PLANNING CONSULTATION RESPONSE

Application No	2026/0083
Proposal	2026 0083 Erection of General-Purpose Agricultural Building Land s of Bents Farm Sheffield Road Cro Edge
Address	Land to the South of Bents Farm Sheffield Road Crow Edge
Date of Consultation Reply	170626
Consultee	Tony Wiles Senior Conservation Officer

PROPOSED GENERAL PURPOSE BUILDING FOR LIVESTOCK, FODDER & BEDDING, AGRICULTURAL PLANT.

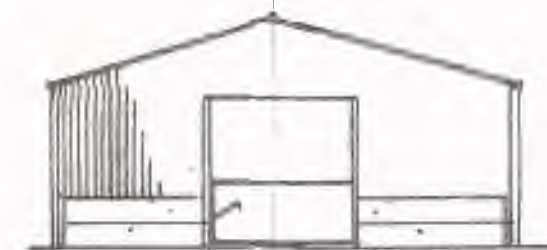
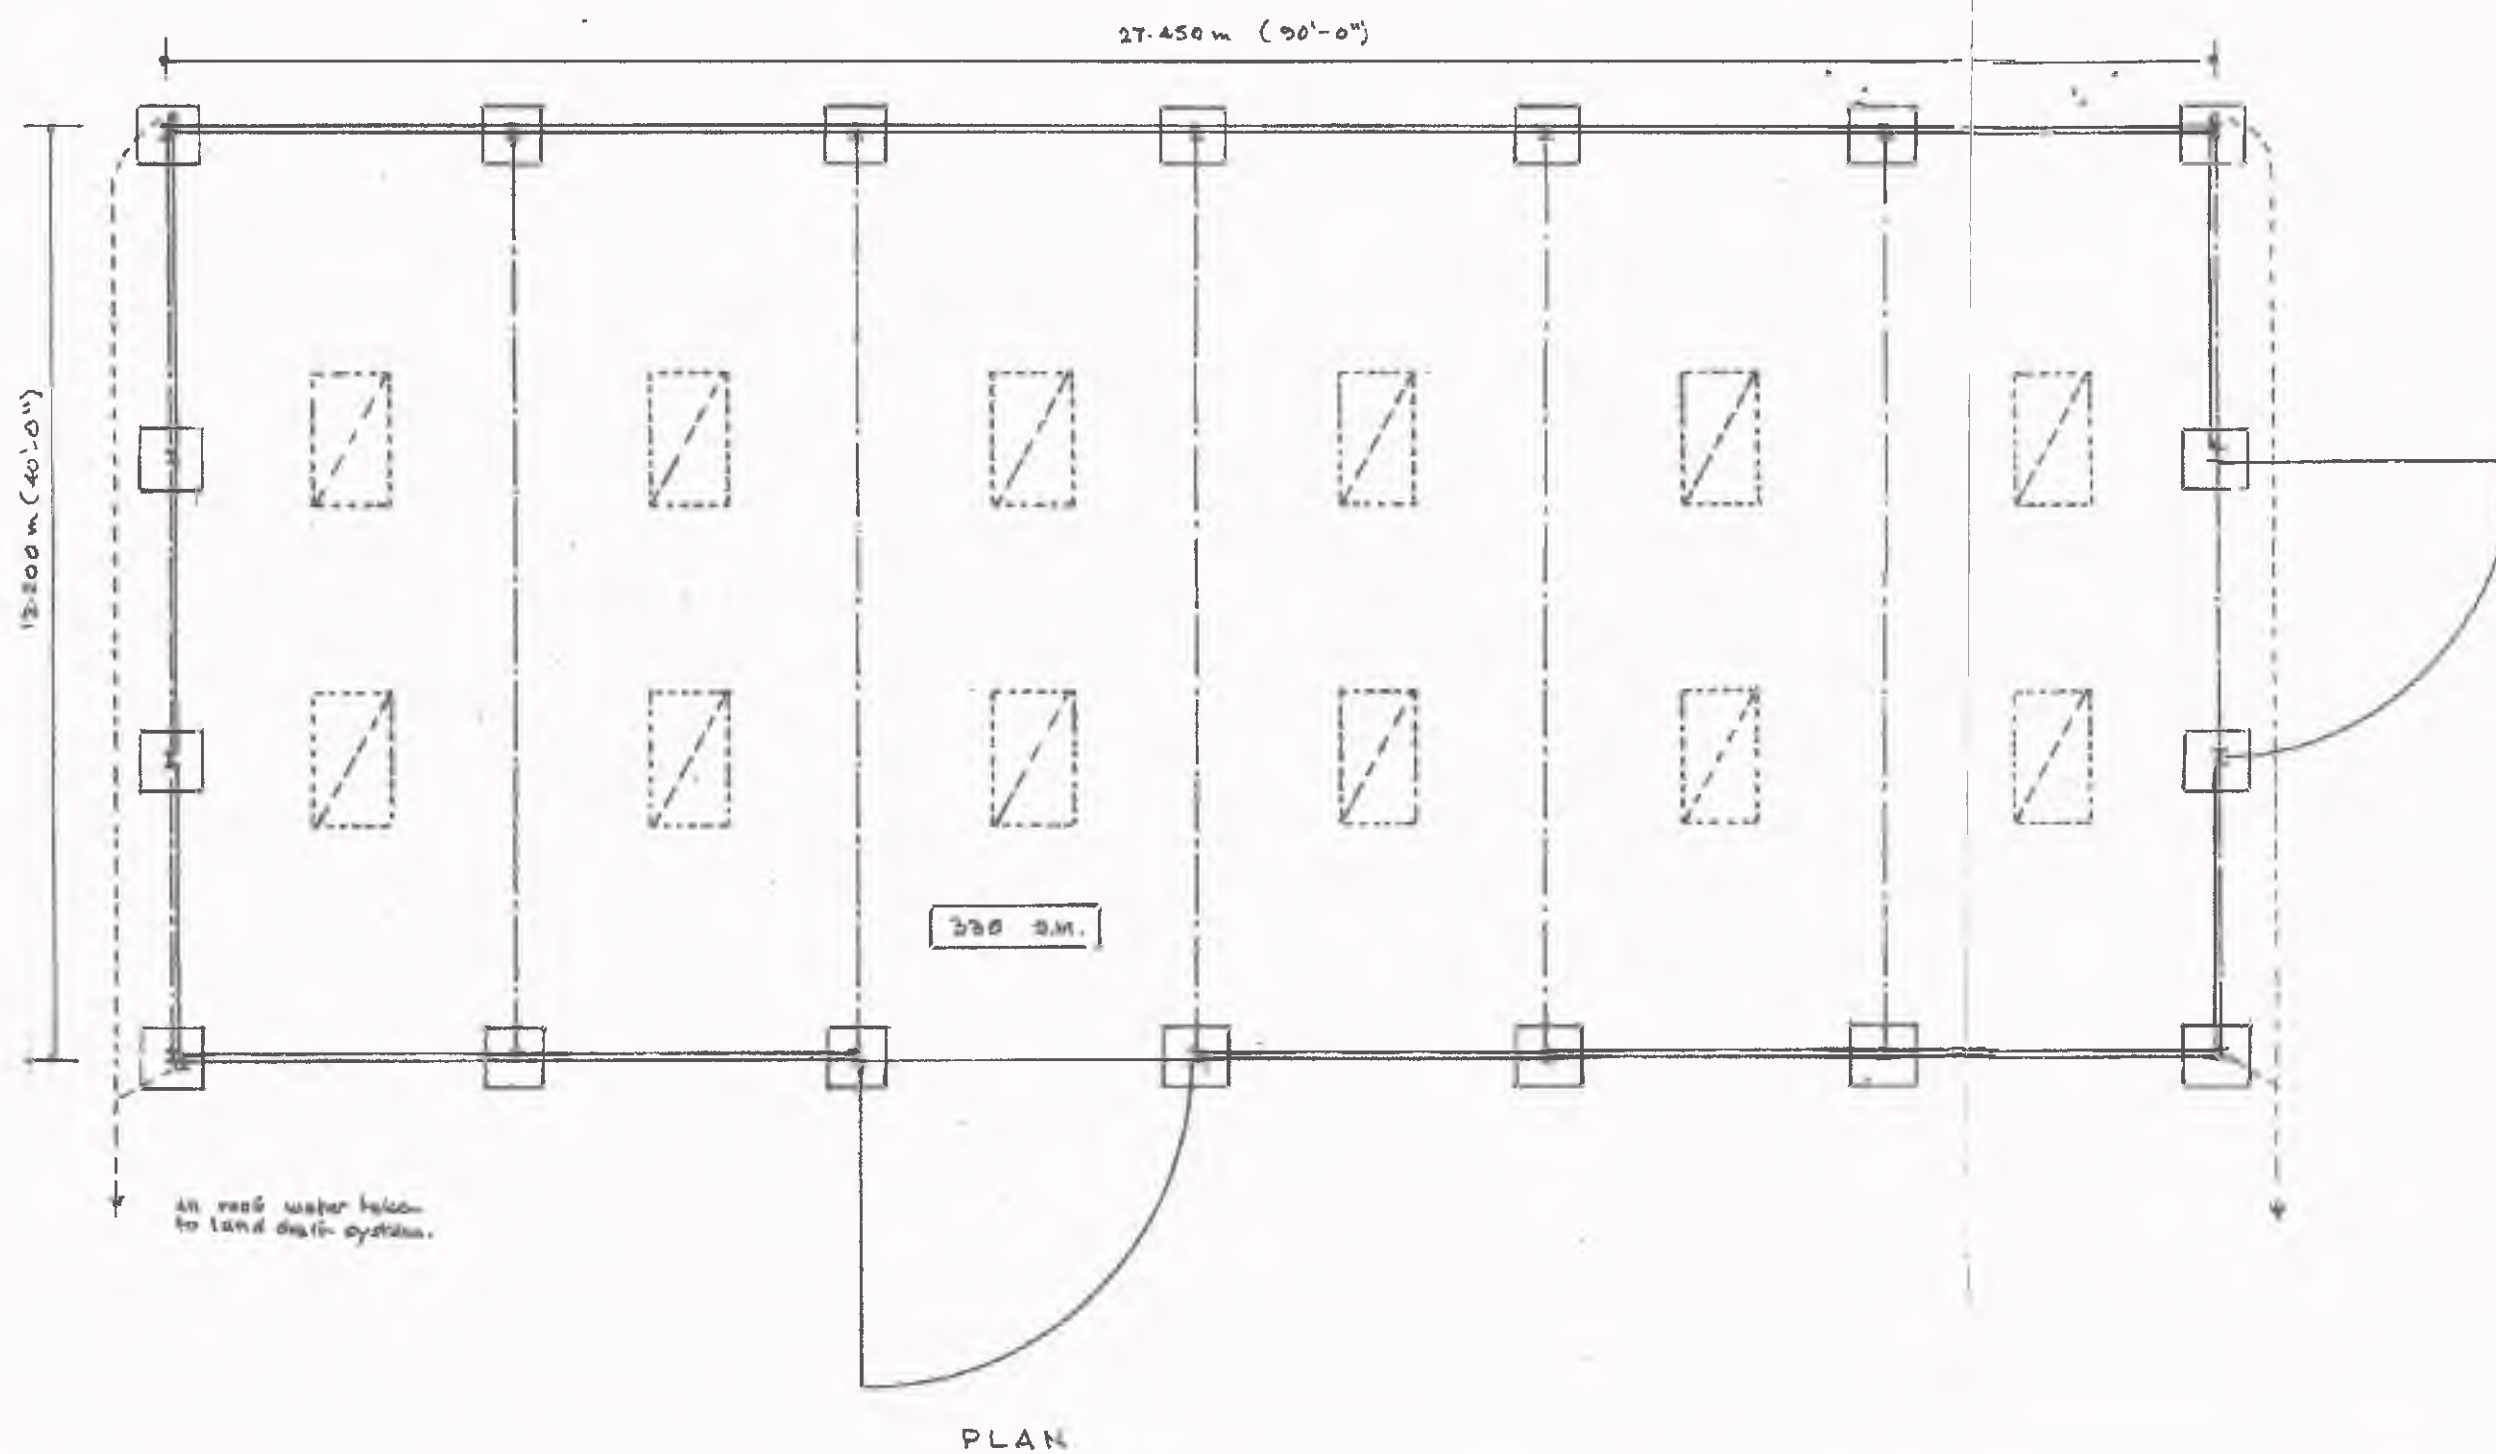
This application seeks permission for the erection of a new agricultural barn on land to the south of Bents Farm. This site is approximately 60m south of the southernmost existing modern barn and approximately 150m south of Bents Farmhouse. The proposed building is a standard portal-framed agricultural structure, comprising a concrete panel plinth with tanalised vertical boarding above and fibre cement roof sheeting. Whilst it is of no particular architectural merit, it is a common and utilitarian building type typically found within agricultural settings. It is understood that the proposed access to the barn is via an existing access point onto the A616 (Manchester Road), presently indicated by a metal farm gate. In respect of the building itself, the proposed structure appears consistent with other modern agricultural buildings within the farmstead and, in that regard, raises no heritage concerns. However, the access is located in very close proximity to a listed milestone (NHLE 1151098). The barn itself would not materially alter the setting of the milestone. The significance of that setting derives principally from its historic relationship with the road and its destinations, which would remain unchanged. Notwithstanding this, clarification is required to confirm that the proposed access arrangement would not necessitate any repositioning or alteration to the Grade II listed milestone. Further clarification regarding the precise positions of both the gate and the milestone would also be welcomed. Subject to satisfactory clarification of this matter, I would raise no objection and have no further detailed conservation comments.
